August 6, 2019  
Project No. 180127E002

Subject: Response to Geotechnical Plan Review Comments and Statement of Risk  
Segmental Block Retaining Walls  
8100 SE 48<sup>th</sup> Street  
Mercer Island, Washington  
**Permit Application No. CA018-010**

References: Geotechnical Engineering Report  
New Retaining Wall Feasibility  
8100 SE 48<sup>th</sup> Street  
Mercer Island, Washington  
Date: October 2, 2018

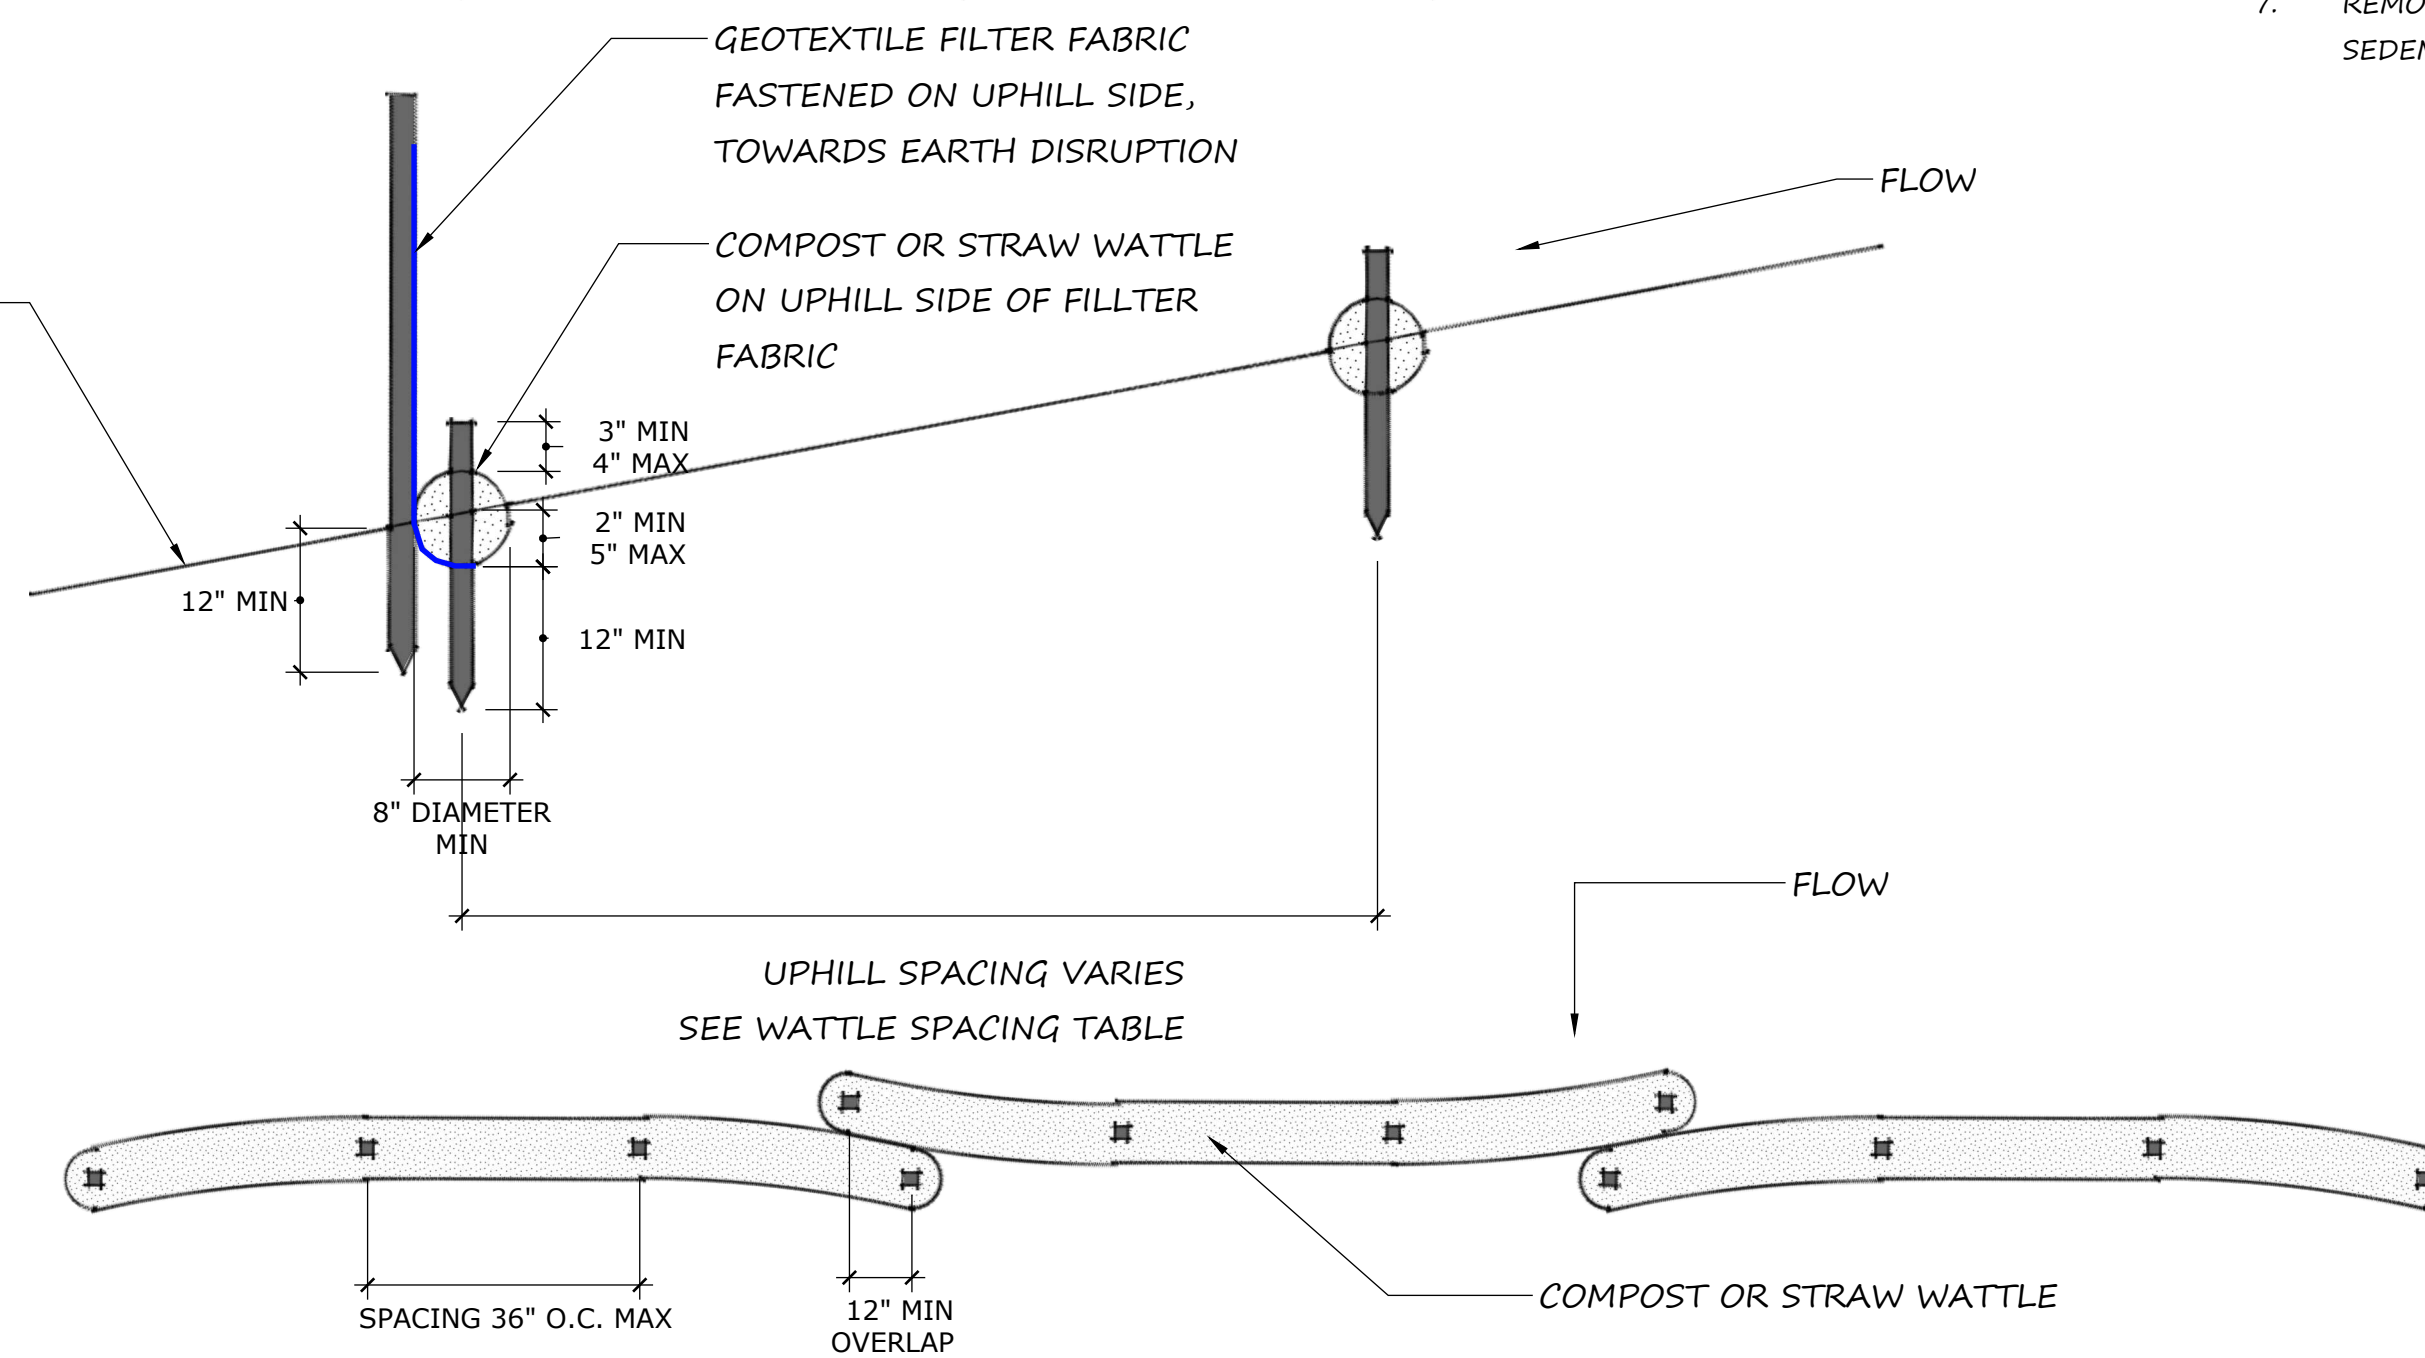
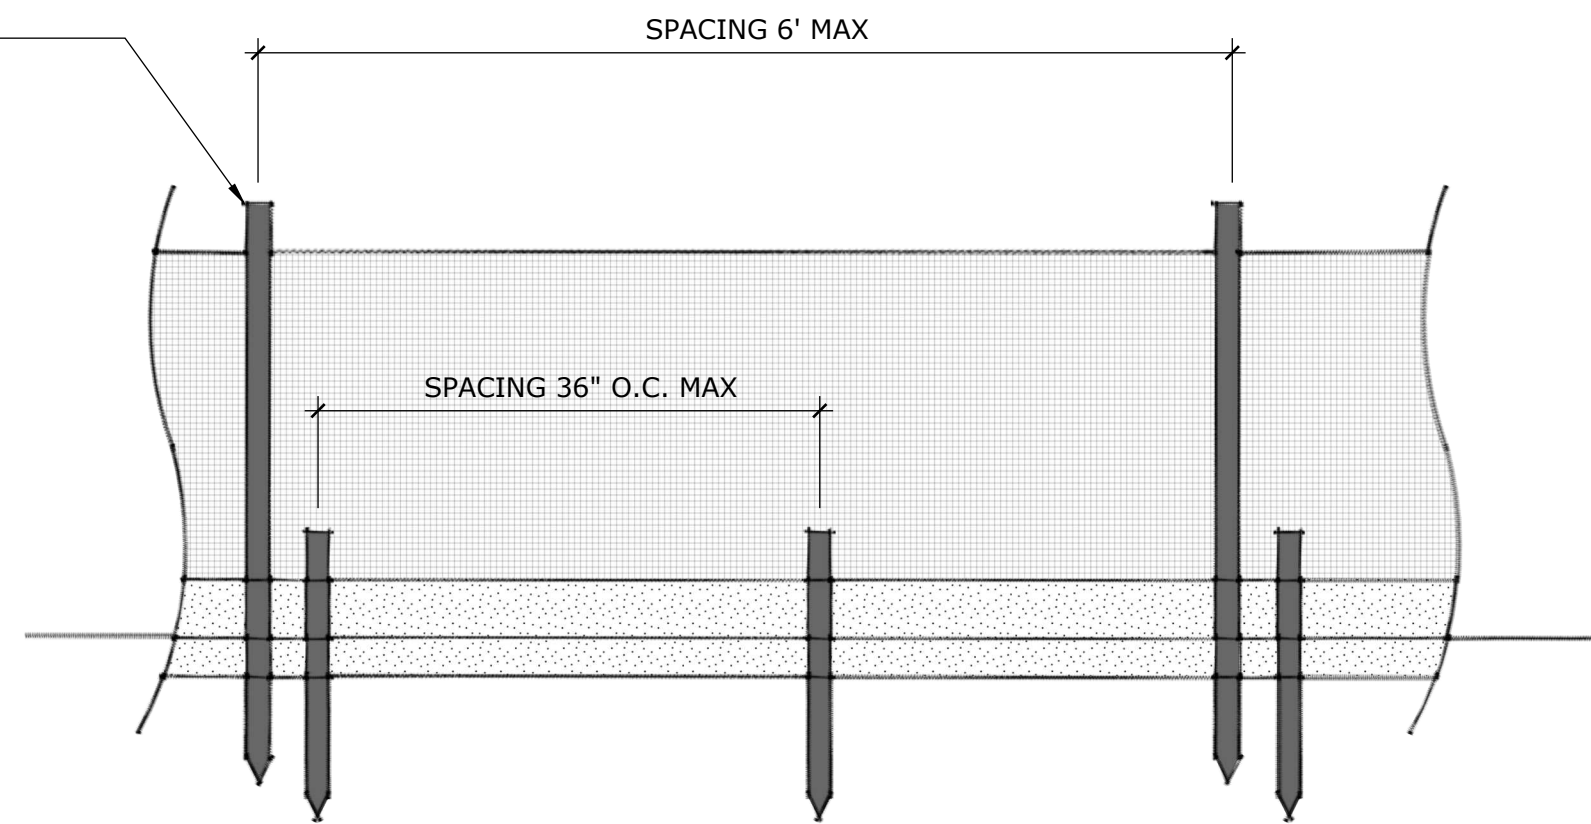
7. “The project civil engineer should provide a Temporary Erosion and Sediment Control plan. The geotechnical report should provide recommendations for permanent erosion and sediment control measures.”

A properly developed, constructed, and maintained erosion control plan consistent with local standards and best management erosion control practices will be required for this project. The project landscape architect is currently preparing a Permanent Landscape Plan and the project civil engineer is preparing a Temporary Erosion and Sediment Control (TESC) Plan in accordance with the City of Mercer Island’s request.

1. All TESC measures for the work area, including properly constructed silt fencing below the proposed work area, should be installed prior to any activity.
2. Sediment socks should be properly installed in any catch basins that could receive stormwater runoff from the proposed improvement area prior to any vegetation clearing or construction of the proposed improvements. These catch basins should be inspected, and sediment socks cleaned and maintained on a regular basis until permanent erosion control measures are in place and functional.

11. All disturbed areas should be revegetated with permanent landscaping approved by the project landscape engineer as soon as possible following construction. If it is outside of the growing season, the disturbed areas should be covered with mulch until permanent landscaping can be established.
